DRB Application No.: 08DRB-70323	Project # 1005474
Project Name: ROSEMONT PARK ADDITION to be know as LOT 8A	
Agent: CATHERINE HELLER	Phone No.: 255-4406

**CITY OF ALBUQUERQUE  
PLANNING DEPARTMENT  
July 23, 2008  
DRB Comments**

**PROJECT # 1005474          APPLICATION # 08-70323**

**RE: Lots 7 & 8, Block 3, Rosemont Park Addition**

**PLAT OF
 LOTS 7-A AND 8-A
 BLOCK 3
 ROSEMONT PARK ADDITION**

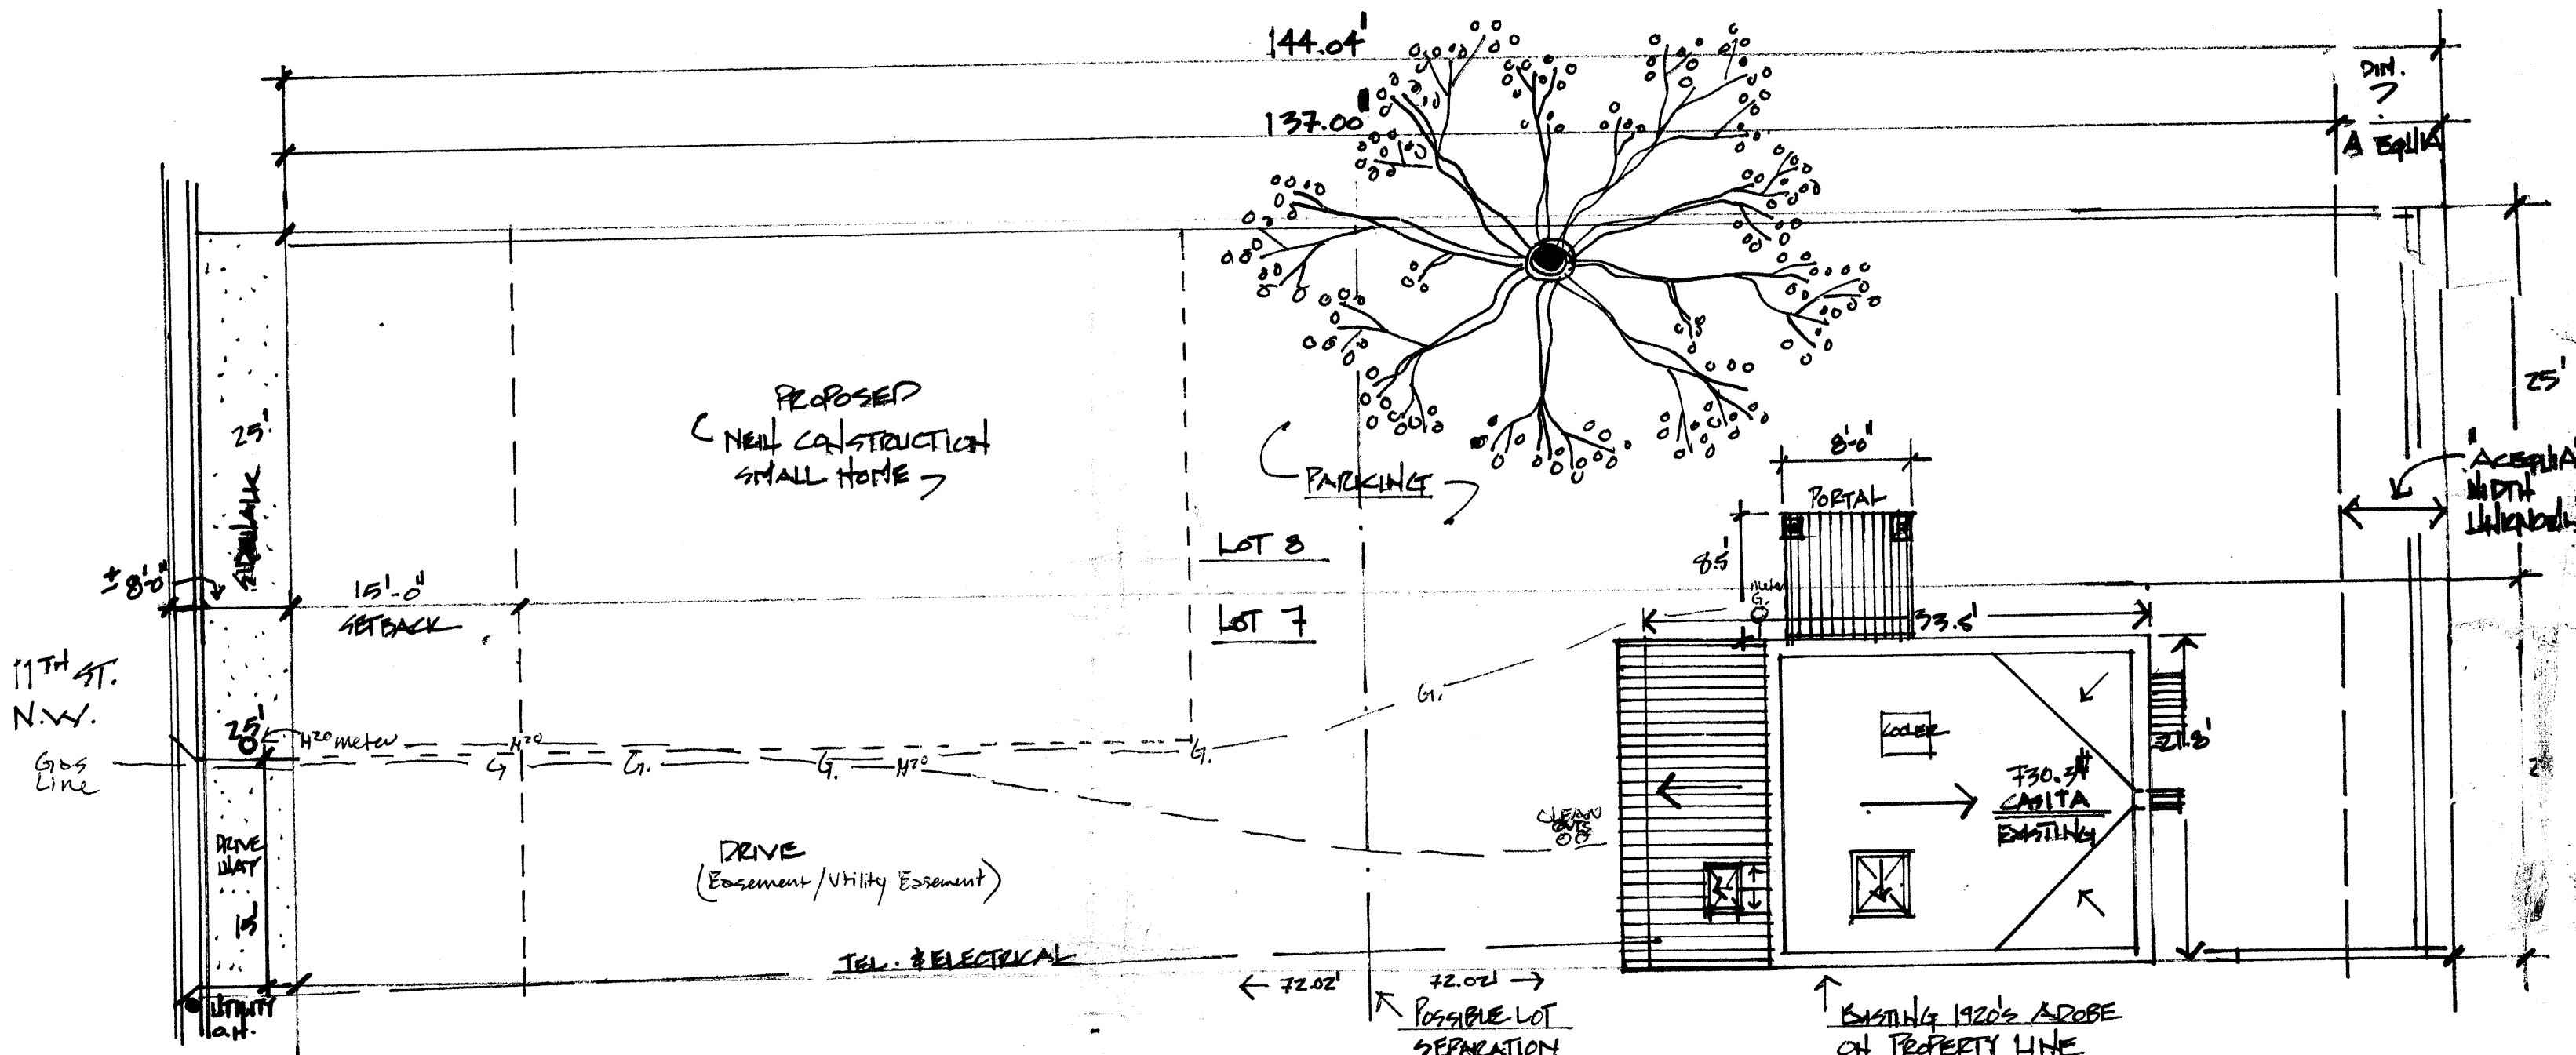
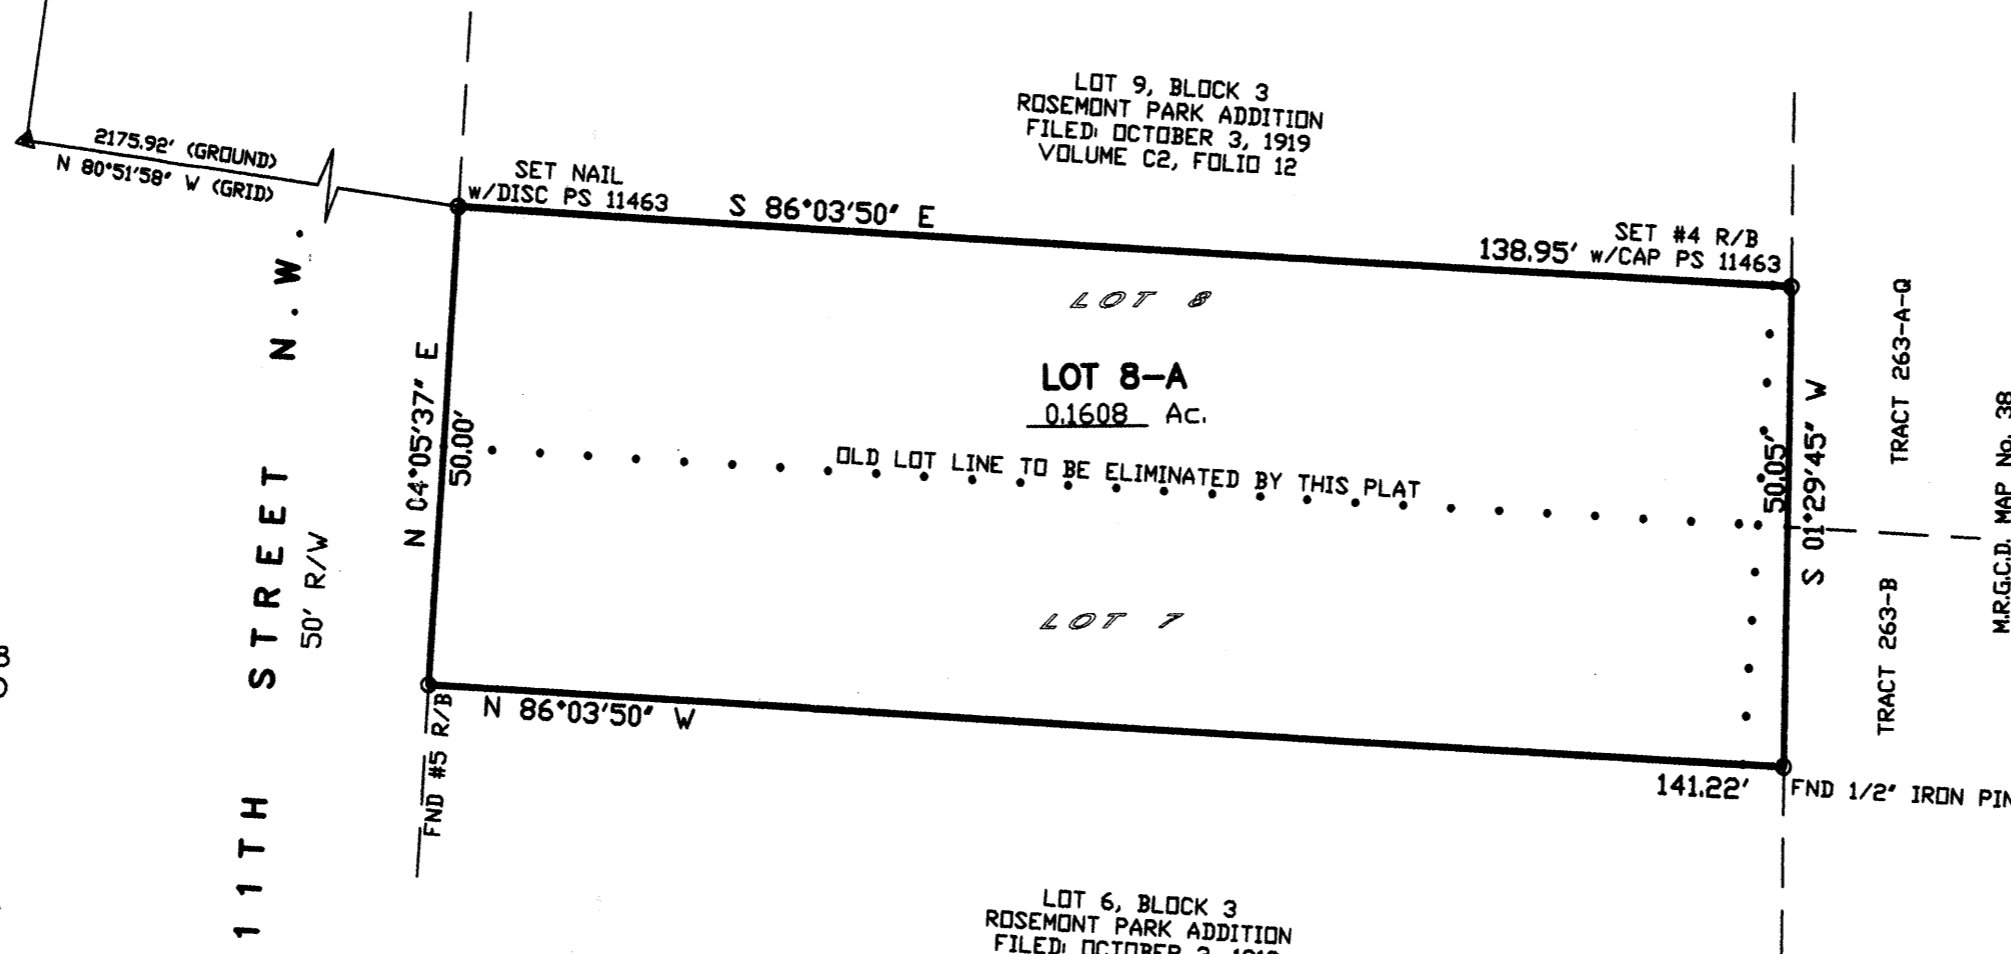
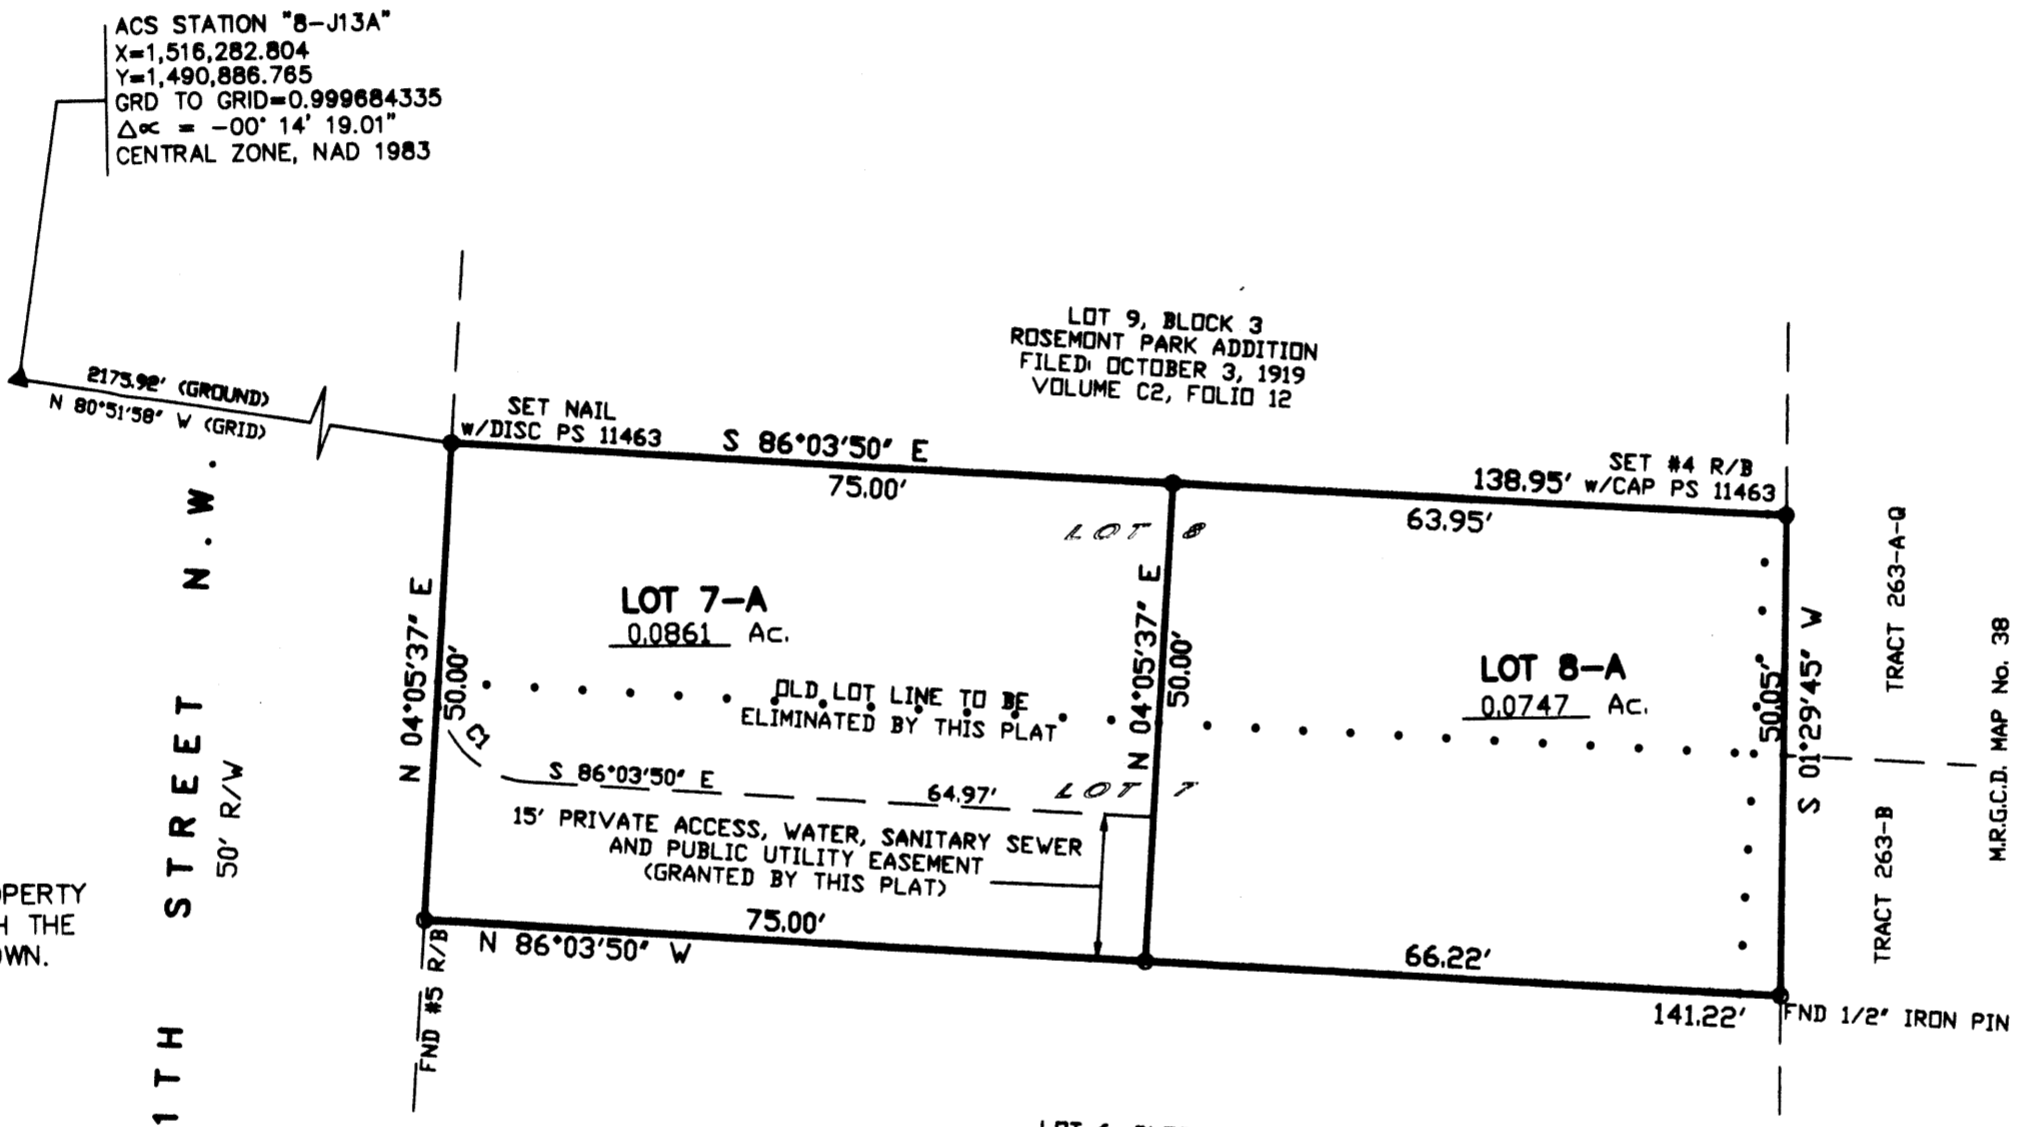
For future reference, please remove the "Current Zoning" note (No. 9) from the plat. Additionally, for the solar collector note, please be specific to this type of request, i.e. use the words "THIS PLAT" and not "REQUESTED FINAL ACTION" in the beginning of the note.

PLANNING (Last to sign): add Maintenance / Beneficiary Statement for 15' Access easement. Condition that the ~~lot~~ variance for lot size be approved through The Zoning Hearing Examiner

The proposed lots do not meet the minimum lot area requirements of the S-R zone, which is 3,500 sq ft (NET – exclusive of any access easement) – a Special Exception for a Lot Size Variance would be required. If these lots were combined as a single parcel, please note that the S-R zone allows two detached dwellings on one lot provided there is a minimum area of 7,000 sq ft and a minimum distance of 10 feet between buildings.

For future reference, please do not identify the property's zoning (Note 9) on the plat. Also, please revise solar note to be specific to this type of request, i.e. use the words "THIS PLAT" and not "REQUESTED FINAL ACTION."
